March 16, 2021

RE: CU-20-00006 – Swiftwater Storage  
SR 970 milepost 1.95 Lt.

We have reviewed the proposed project and have the following comments.

WLC PROPERTY HOLDINGS LLC
SITE PLAN

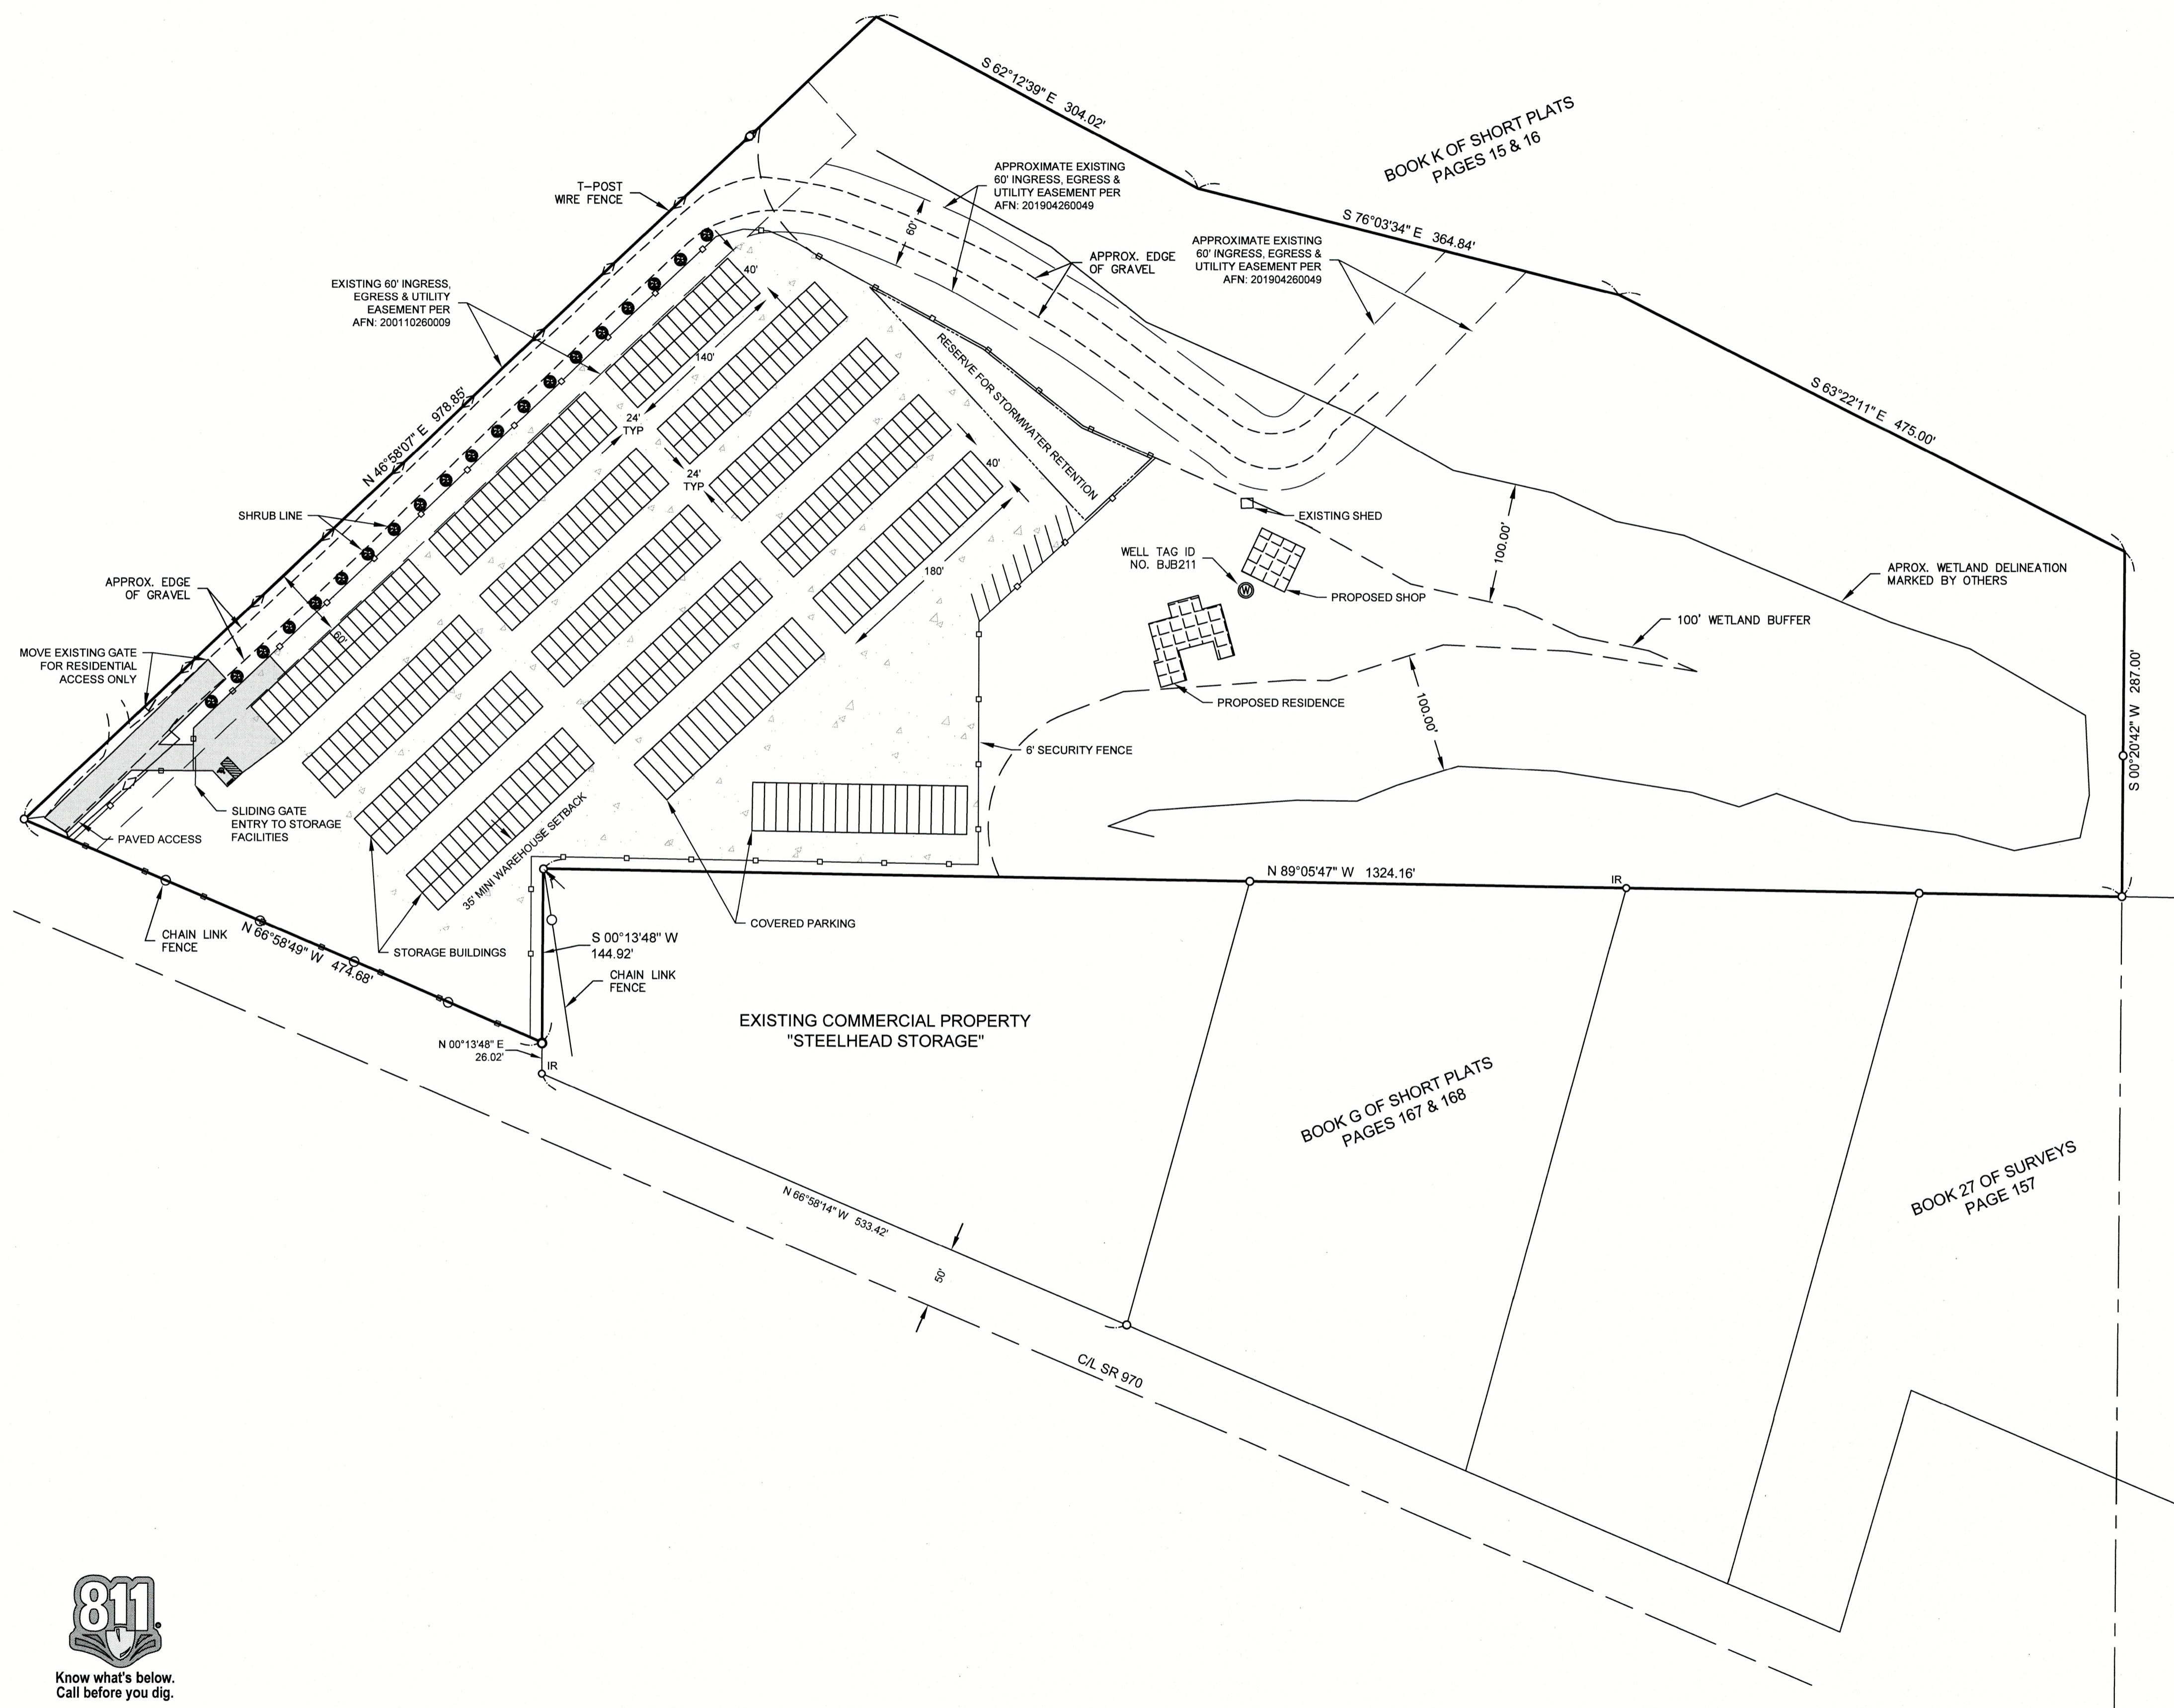
- Any proposed lighting must be direct down towards the site and away from SR 970.
- Stormwater or surface runoff generated by this proposal must be retained and treated on site. An approved utility permit is required for any discharge of water onto SR 970 right-of-way.

- In this location, WSDOT right-of-way extends 75' from the highway centerline. The proponent should be aware, any encroachment, including but not limited to grading, fencing, or landscaping, will not be allowed within the highway right-of-way.
